## DELEGATED HOUSEHOLDER DECISION

<b>Item No.</b>	<b>Report of the Head of Development Management and Building Control</b>		
<b>Address:</b>	9 FRAYS AVENUE WEST DRAYTON		
<b>Development:</b>	Erection of a first floor rear extension, garage conversion, new windows to front, amendments to fenestration and alterations to roof form. Alterations to driveway and new vehicle parking with charging bays.		
<b>LBH Ref Nos:</b>	5352/APP/2023/1875		
<b>Drawing Nos:</b>	KP092023B KP092023C KP092023A option 3 KP092023D		
<b>Date Plans received:</b>	<b>Date(s) of Amendments(s):</b>	18-08-23	
		18-08-23	
<b>Date Application valid</b>		27-06-23	
		18-08-23	
		27-06-23	
		18-08-23	
		27-06-23

DRAWING TITLE	PLANS AND ELEVATIONS
DRAWING No.	KP092023A

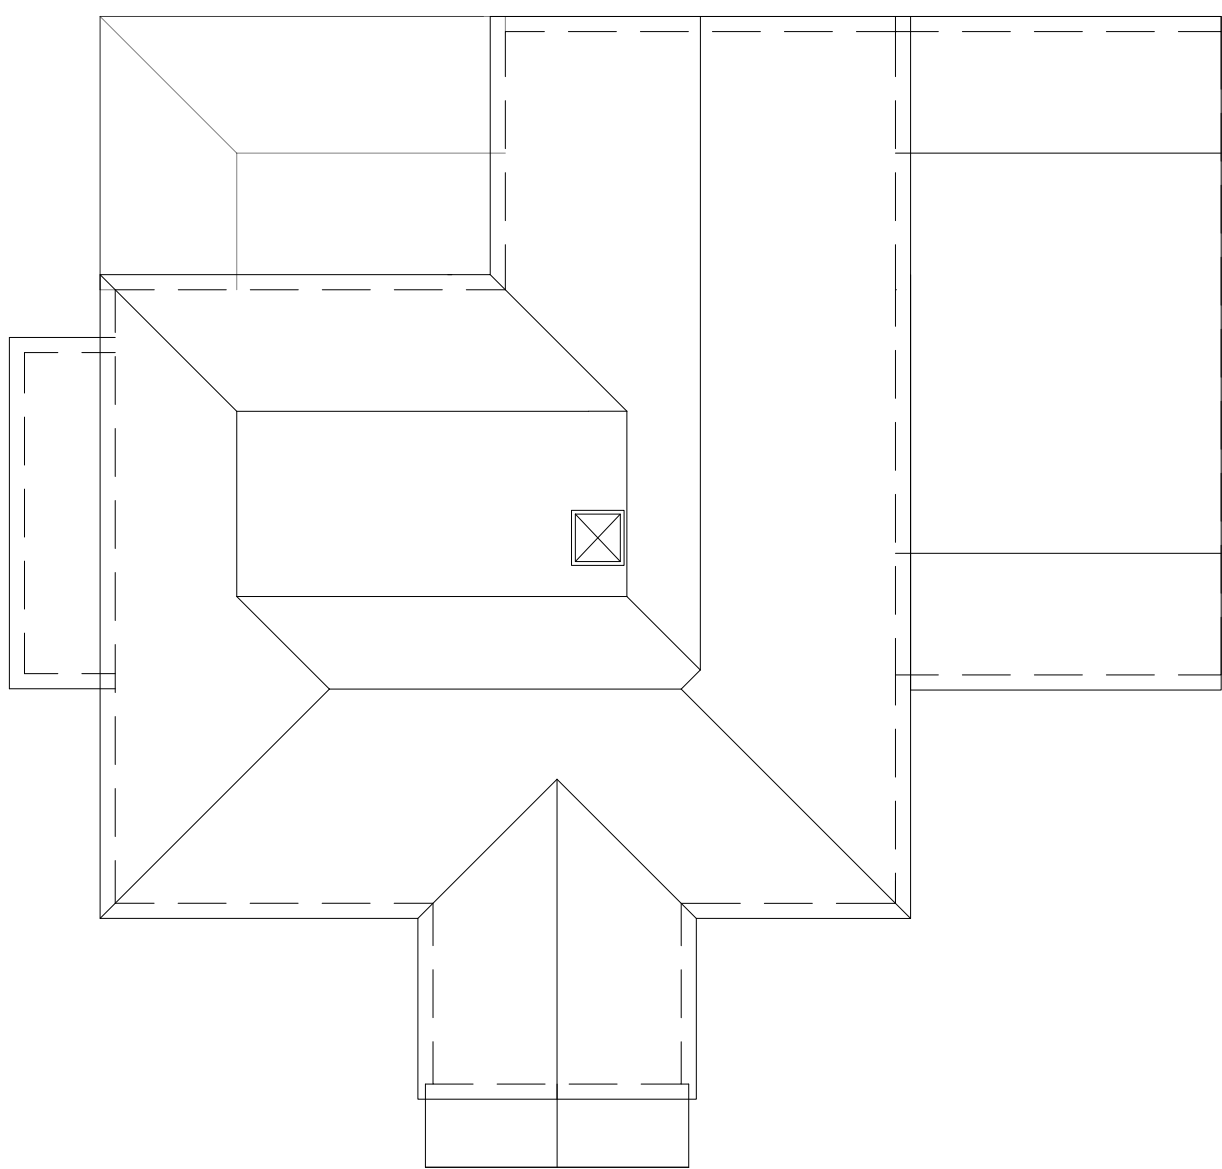
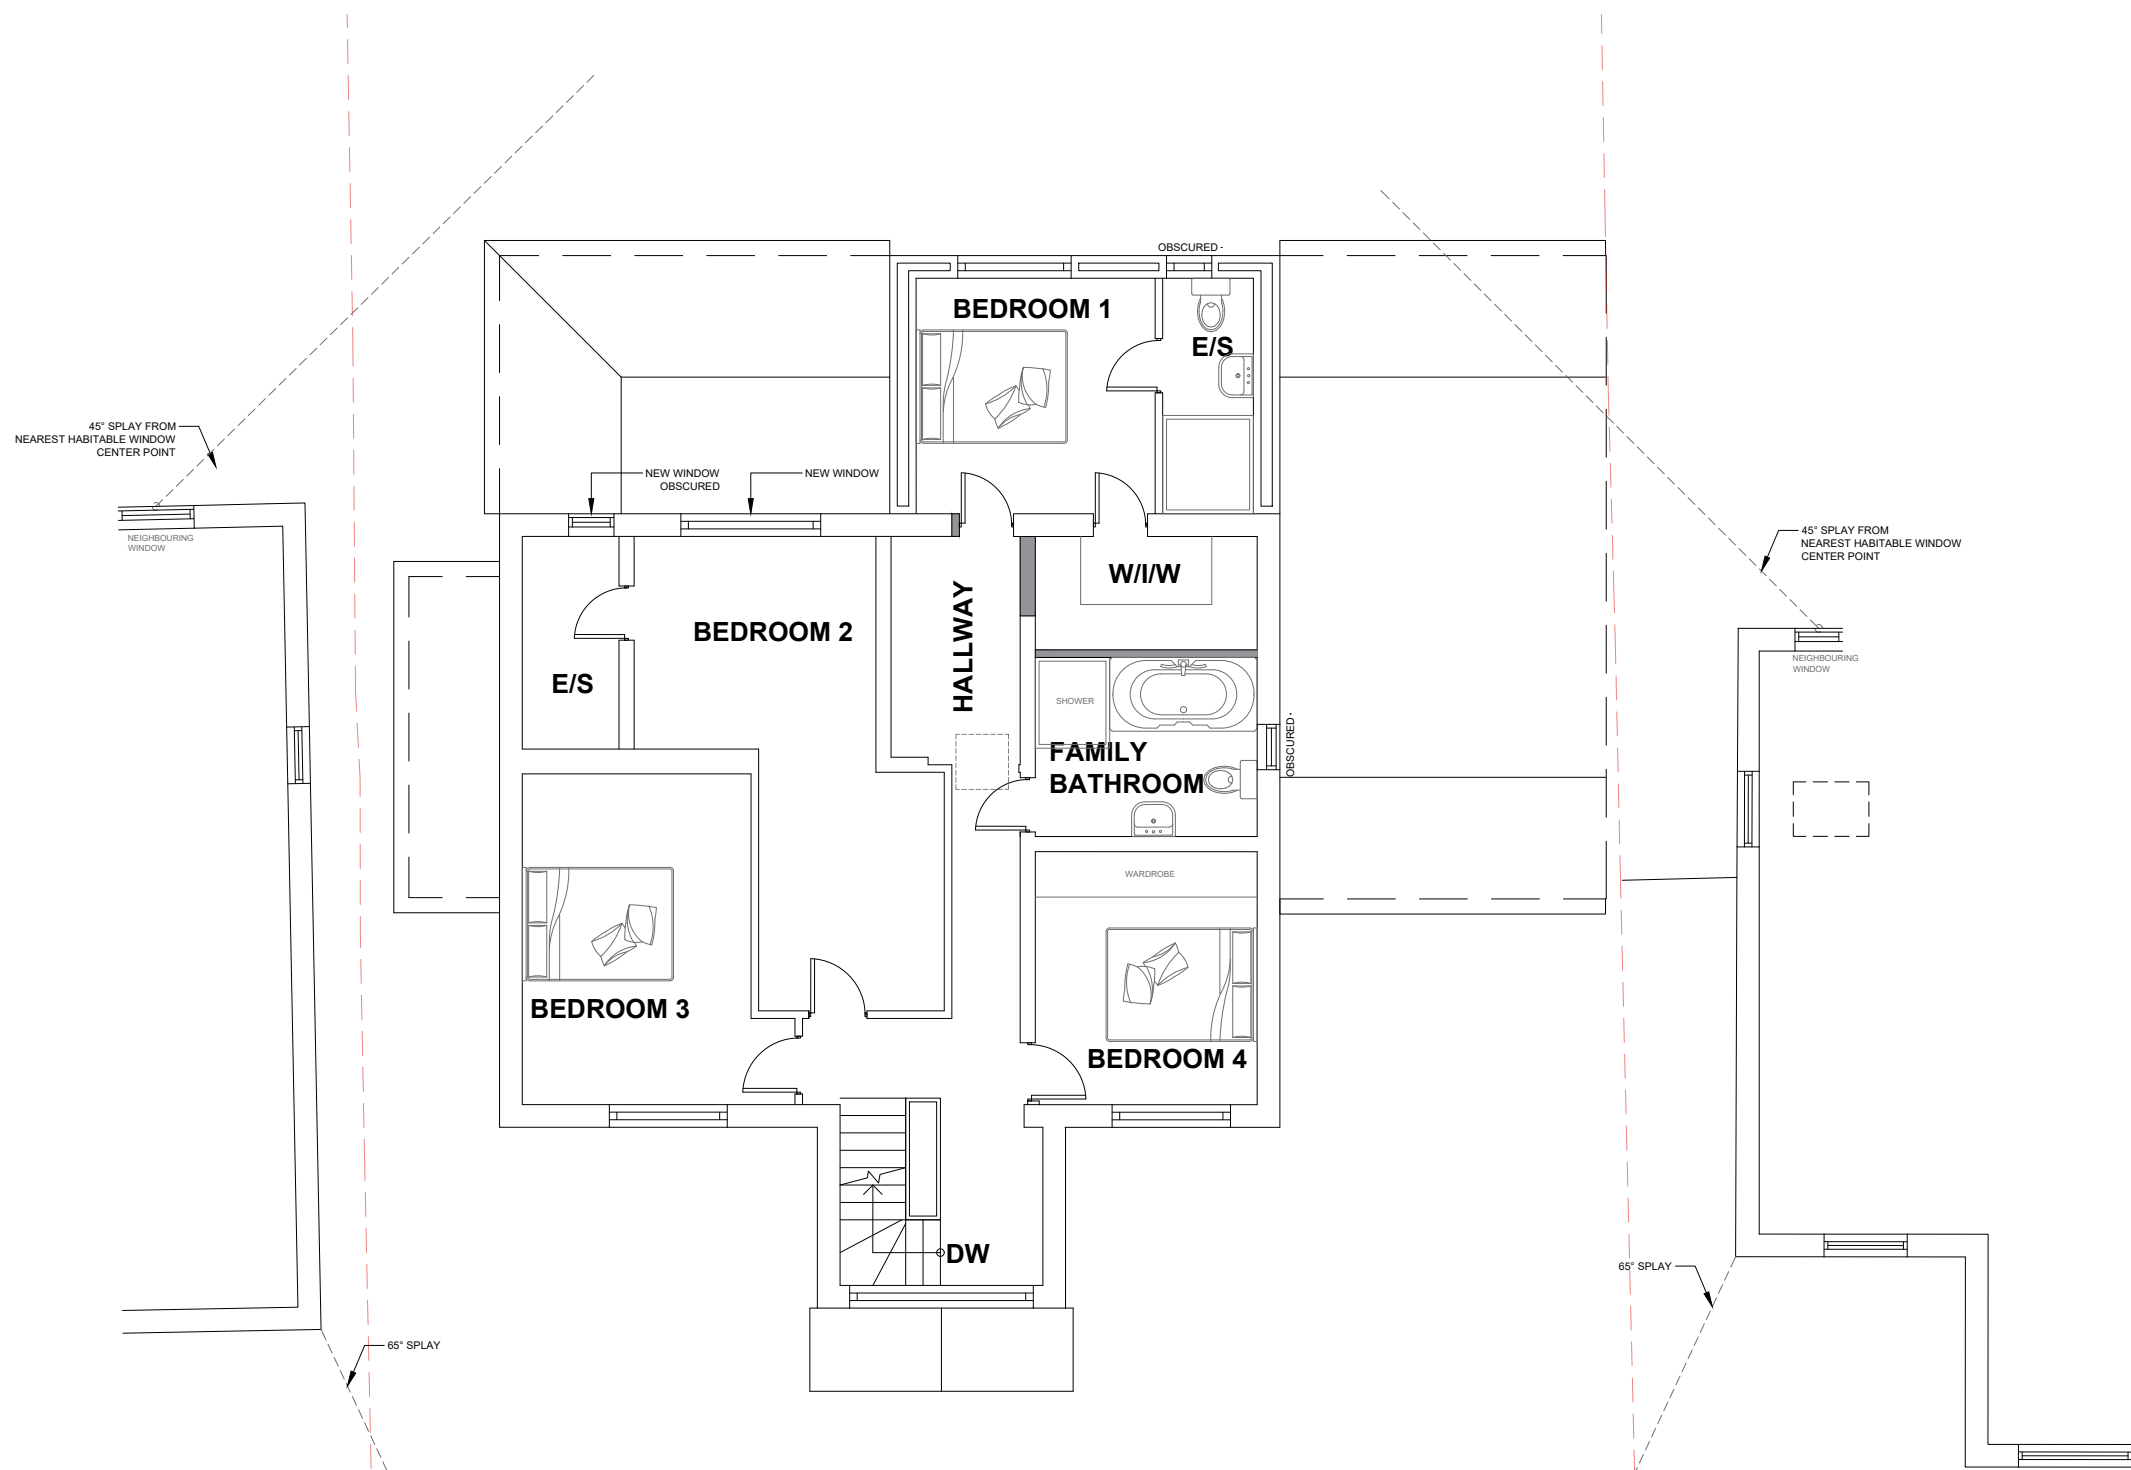
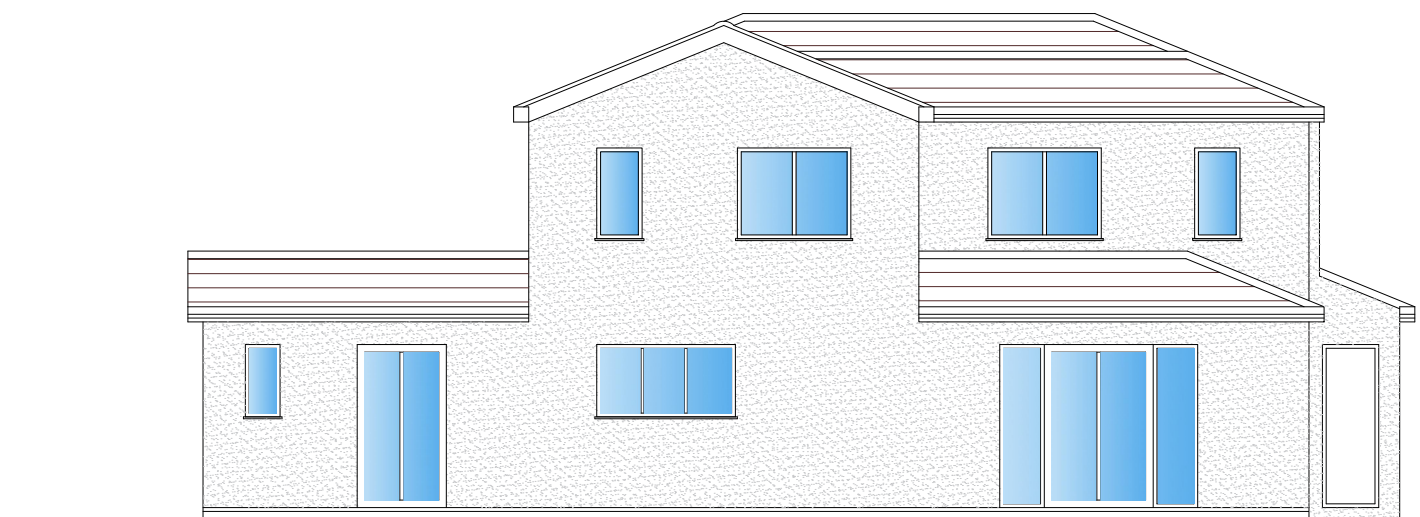
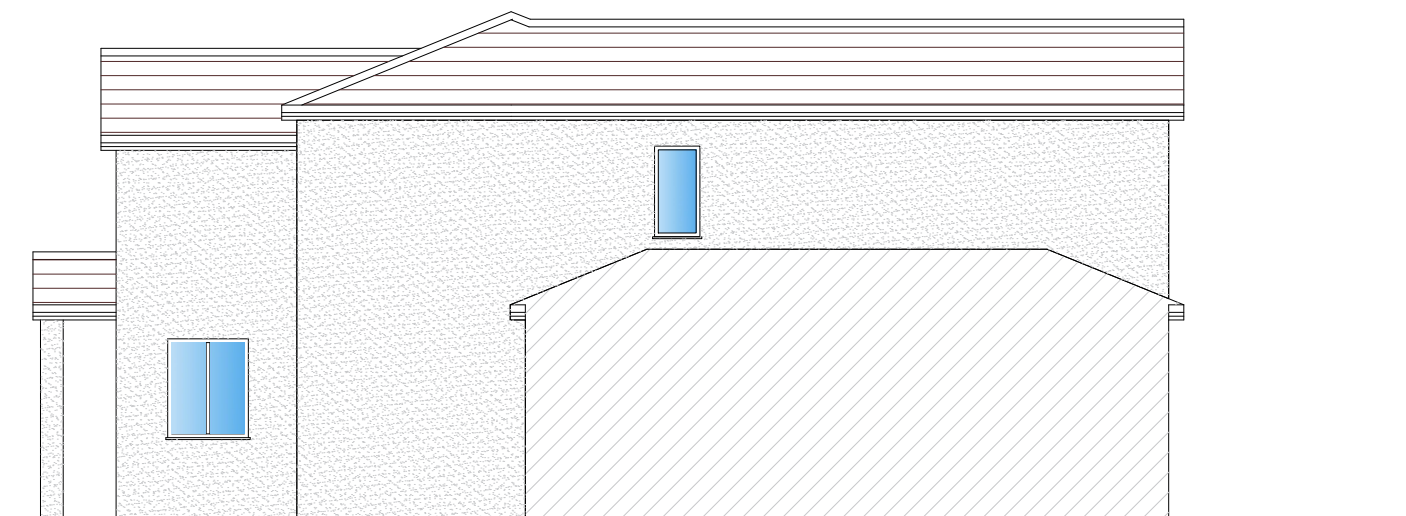
West Drayton Conservation Area Advisory Panel: I am writing on behalf of West Drayton Conservation Area Advisory Panel. The design and scale of the proposals, like those of the previous application (5352/APP/2021/3242 - that was refused) are completely unacceptable; we expect this application also to be refused.

Officer Comment: Amended plans were received on 18th August 2023, illustrating that the width of the first floor rear extension is significantly reduced and that it would not exceed more than half the width of the original dwellinghouse. Furthermore, the Council's Conversation and Urban Design officer has reviewed the application has raised no objection to the amended plans.

The proposed first floor rear extension would measure approximately 5m (w) x 3.4m (d) x 4.1m (h). The proposed first floor rear extension would comprise a pitched roof and would be set down from the existing roof ridge by 0.2m. The proposed extension would be set in from either side boundaries by over 4 metres. The proposal also involves roof alterations towards the rear by raising the existing roof ridge up to the new ridge line of first floor rear extension.

The proposed first floor rear extension would extend beyond the rear elevation of Nos. 7B and 11 Frays Avenue, however the proposed extension would be sited approximately 4m from both side boundaries and the plans illustrate that the proposal would comply with the 45 degree rule. In addition, no side facing windows are proposed to face towards the adjacent neighbouring properties and therefore it is not considered that the proposal would have a detrimental impact on loss of sunlight/daylight, loss of privacy or would appear visually overbearing.

Amended plans were received on 18th August 2023 reducing the width of the first floor rear extension.
